Caitlin Cameron - Review Comment for 169 Newbury St

Memo To: Caitlin Cameron
 Barbara Barhydt
 From: David Margolis-Pineo
 Re: 169 Newbury St – Luminato Condominiums

5 CATCHBASIN #2 SECTION (II-2)
NOT TO SCALE

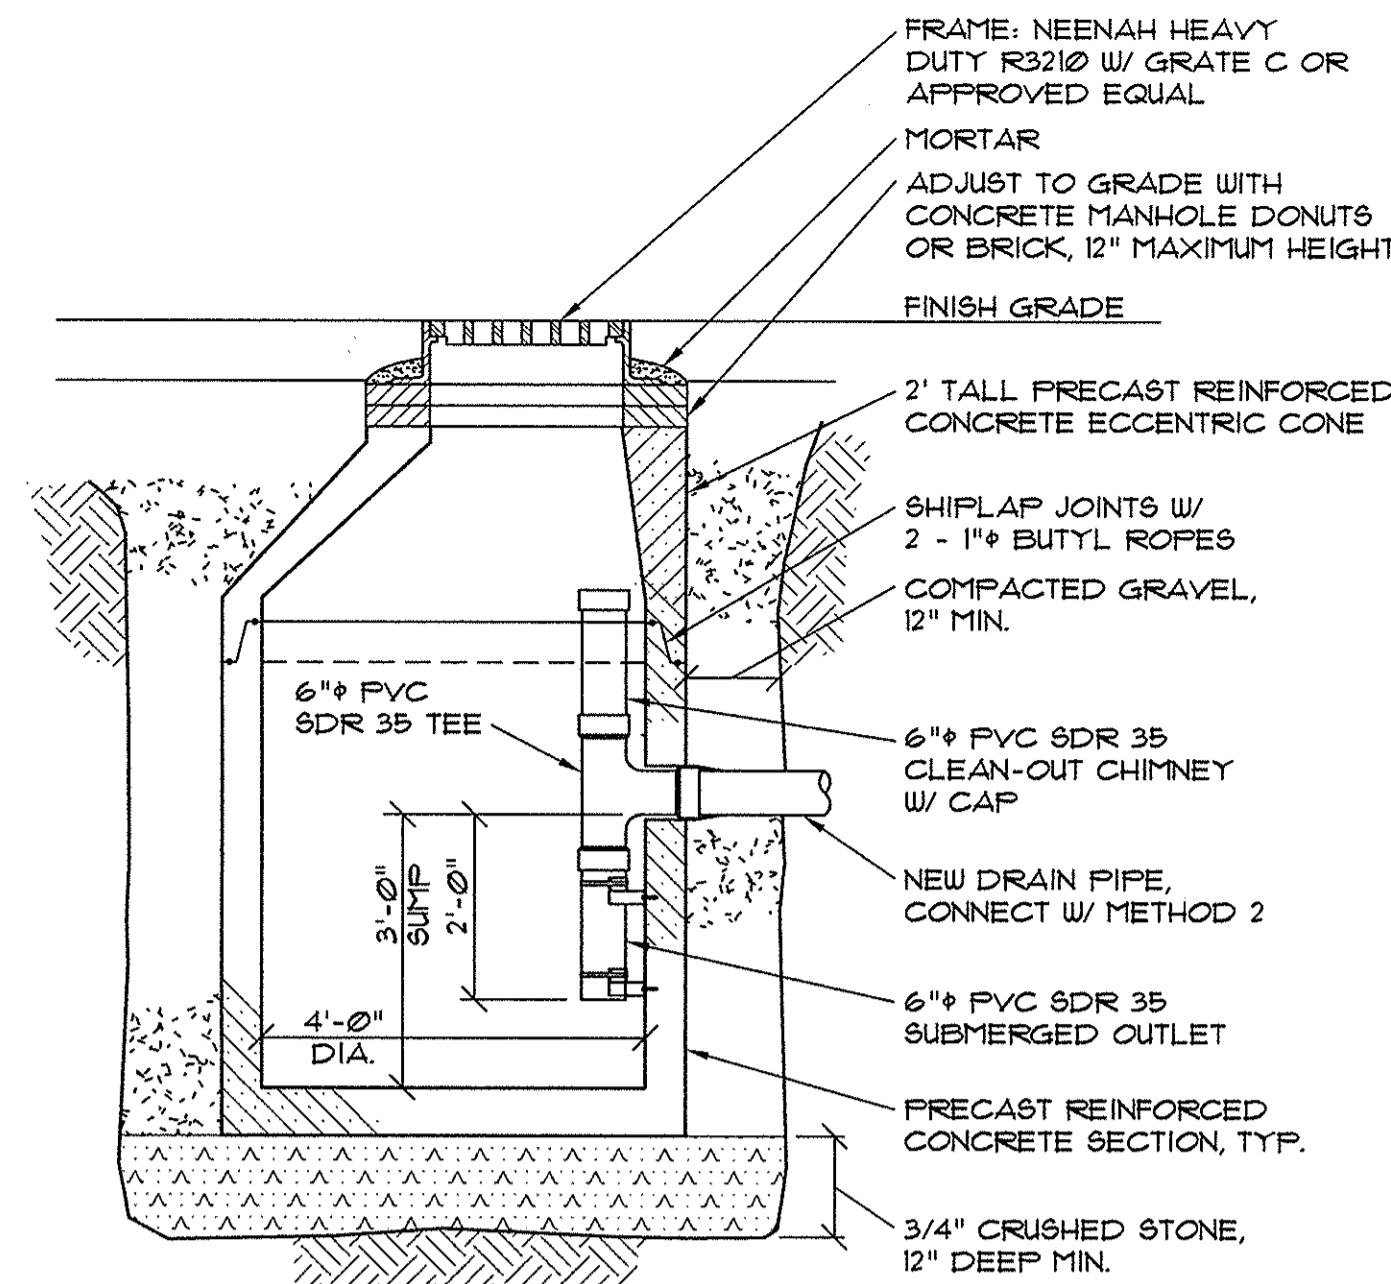
3. A temporary construction easement will be required from the City to construct this project due to the encroachment of Franklin St.
4. It is understood that all roof and site drainage will be directed to proposed catchbasin #2 in Newbury St. or to the ground and not the sanitary sewer system. Please confirm that this is the case. Please note that N-12 is not permitted within the street right of way. Please consult Chapter Two of the City's Technical Manual for acceptable pipe material options.

7. An oil/grit separator will be required within the parking garage on both levels. Modifying the proposed catchbasin to include a three foot sump and down turned 90 degree bend to allow for one foot of oil capture is acceptable. Please show detail and indicate oil/grit locations on plans. Please keep the sanitary lateral connections downstream of the oil/grit separators and change the designation of the line from SD leading to the City's sanitary sewer.

8 TYPICAL BACKFLOW PREVENTOR DETAIL
NOT TO SCALE

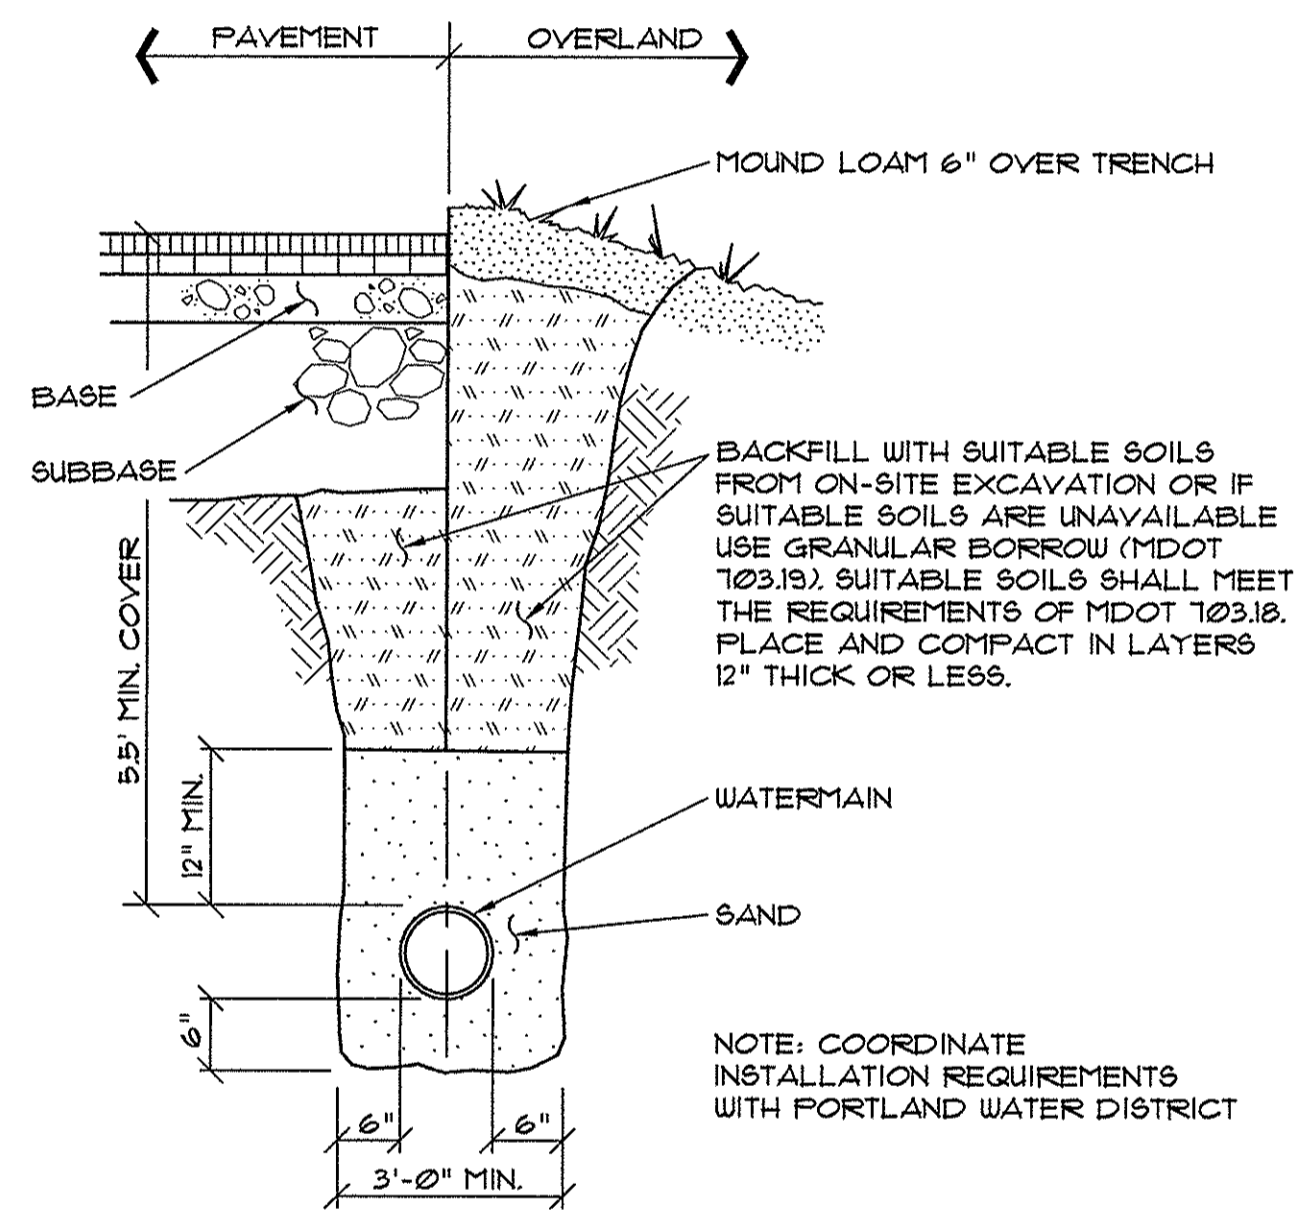
8. Since the sewer systems are separated, a backflow preventer on the sanitary lateral is not required by the city. If the applicant wishes to install one, please place the backflow preventer on the applicant's property.

**5 BITUMINOUS DRIVEWAY APRON (I-13)**  
NOT TO SCALE

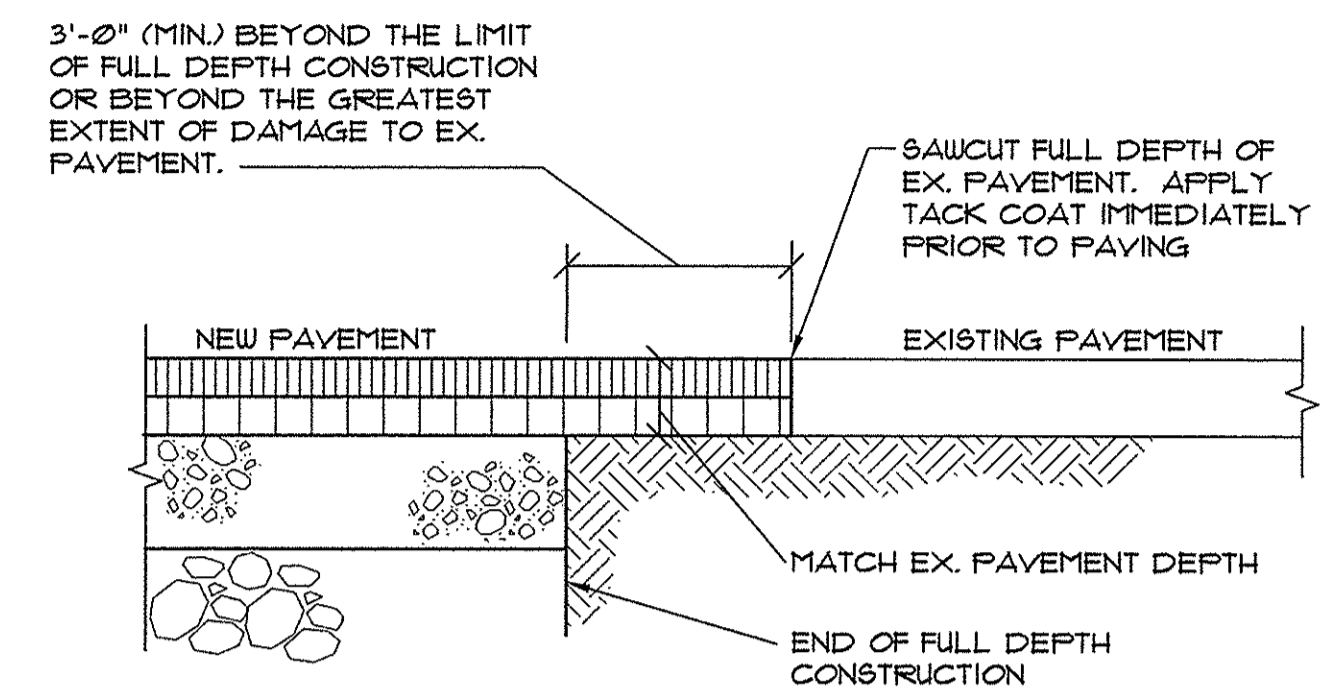
5. The applicant is showing a brick driveway apron within the street right of way on Newbury St. This is a deviation of the City's material policy which calls for an asphalt apron. This department is supportive of a waiver request however the applicant will need Council approval and signoff on maintenance agreement of the drive apron within the road right of way.
